KITTITAS COUNTY

MEMORANDUM

TO: Dusty Pilkington, CDS
FROM: Kelly Bacon, Engineer Technician I
DATE: October 3, 2016
SUBJECT: Mitchell BL-16-00013 **KB**

**CRUSE & ASSOCIATES**  
 PROFESSIONAL LAND SURVEYORS  
 217 East Fourth Street P.O. Box 959  
 Ellensburg, WA 98926 (509) 962-8242  
**MITCHELL PROPERTY**

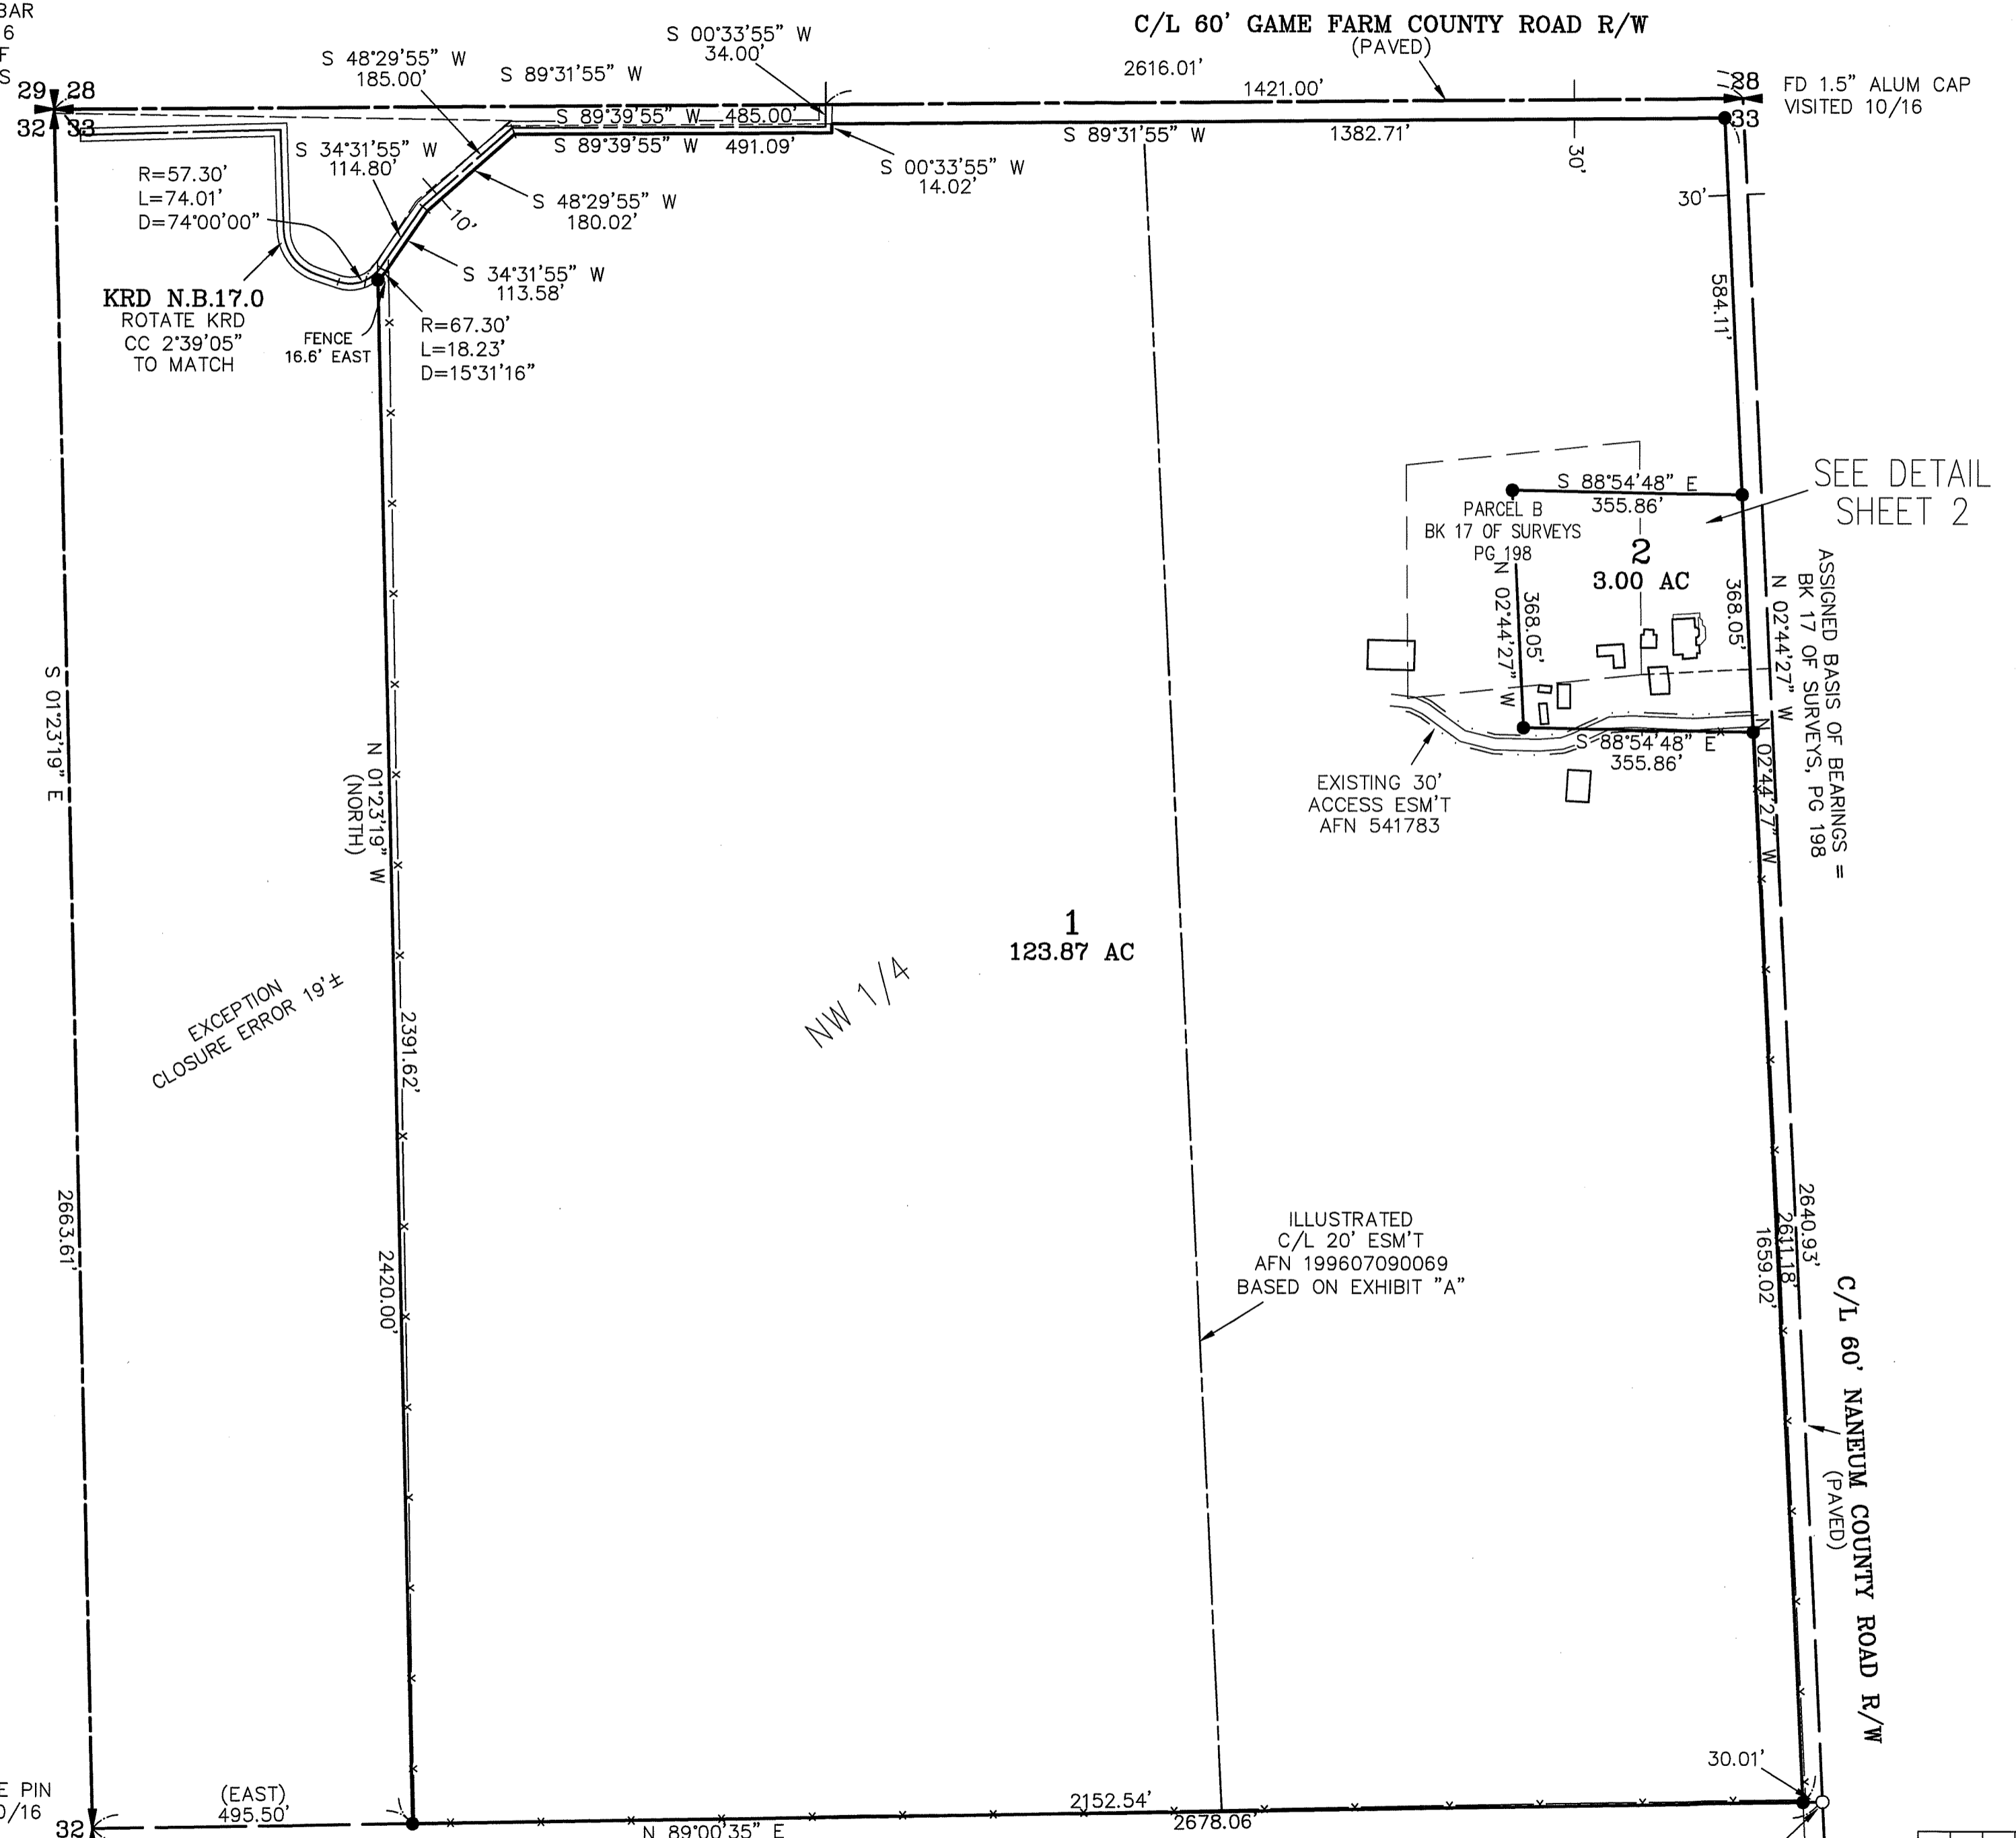
- A. A 30' joint-use driveway easement needs to be shown on the face of the survey.
- B. All County Road Standards dated December 15, 2015 will apply to the division of land.
